## **Oulton Parish Council's submission at Deadline 6**

VATTENFALL: Norfolk Vanguard

Since the last deadline, Oulton Parish Council (OPC) has attended an Accompanied Site Inspection (ASI) on March 25th, an Issue Specific Hearing on March 27<sup>th</sup> and a Working Group meeting with the Applicant in Oulton, also on March 27<sup>th</sup>.

Figure 1 Location of Old Railway Gatehouse

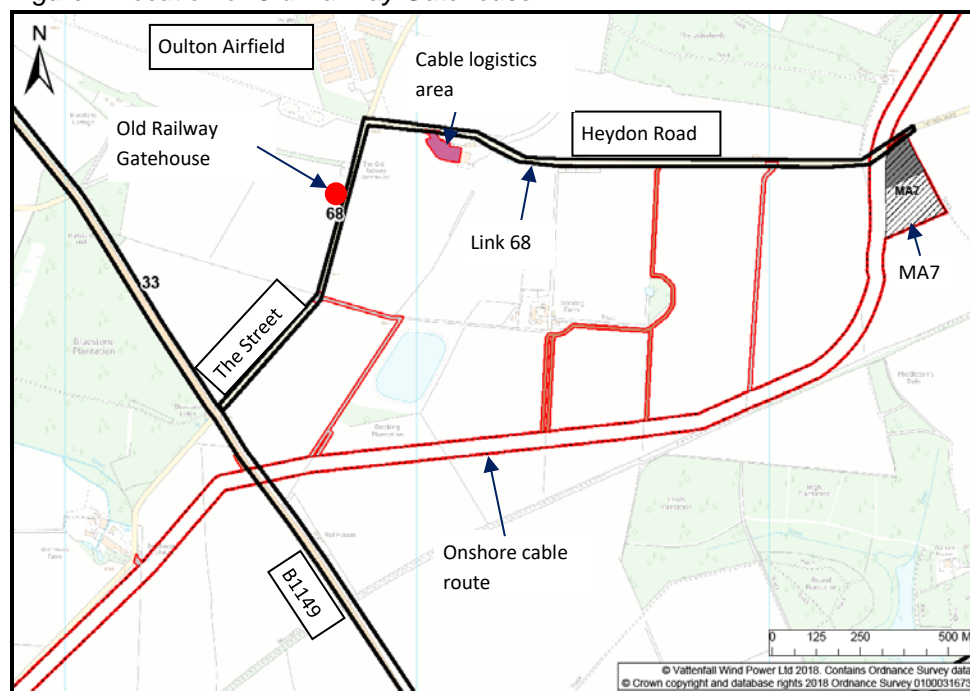
4. The Parish Council is similarly concerned about the apparent lack of an air quality assessment. Neither project has seen fit to carry out such an assessment for the residents of the Old Railway Gatehouse, who will be severely impacted by HGV particulate emissions for the entire duration of both projects – **with the anticipated cumulative HGV traffic increase estimated between 487% and 548% by the two project teams.**

4.1 OPC raised the point at the ISH on 27<sup>th</sup> March 2019 that an air quality assessment had not been carried out for LINK 68. The applicant replied that this *had* been carried out and detailed in the cumulative impact assessment, which was submitted at Deadline 5.

OPC would like to point out that *LINK 68 has been omitted* and did not feature either in previous air quality assessments or in the updated CIA for deadline 5. If we are mistaken, then we seek clarification from the Applicant and request that they direct us to the appropriate documentation.

4.3 The nearest receptor in the assessments referred to above, and in the current CIA was R79, which is on the B1149 (Holt Road). The Street, Oulton - including The Old Railway Gatehouse - *has not been assessed*. It would be assumed that an air quality assessment should have been carried out at The Old Railway Gatehouse as a sensitive receptor, as there would be the cumulative impact of 214 HGVs daily and the property is within only 2 or 3 metres of the highway.

4.4 The criteria used by HOW3 for judging the necessity for assessment of air quality at a specific site was the IAQM guidance (IAQM, 2014). This states that a detailed assessment is required where there are human receptors within 350m of the site boundary and/or within 50m of the route(s) used by construction vehicles on the public highway, up to 500m from the site entrance(s).

The Old Railway Gatehouse qualifies for a “detailed assessment” of air quality when judged by these criteria, but was not so assessed by HOW3.

4.6 In conclusion, given that HOW3 did not assess the Gatehouse for air quality, and that the Examination process for Hornsea Three has now closed, *with this matter unresolved*, OPC calls upon Vattenfall to carry out a cumulative air quality assessment for the Old Railway Gatehouse, as a matter of urgency.
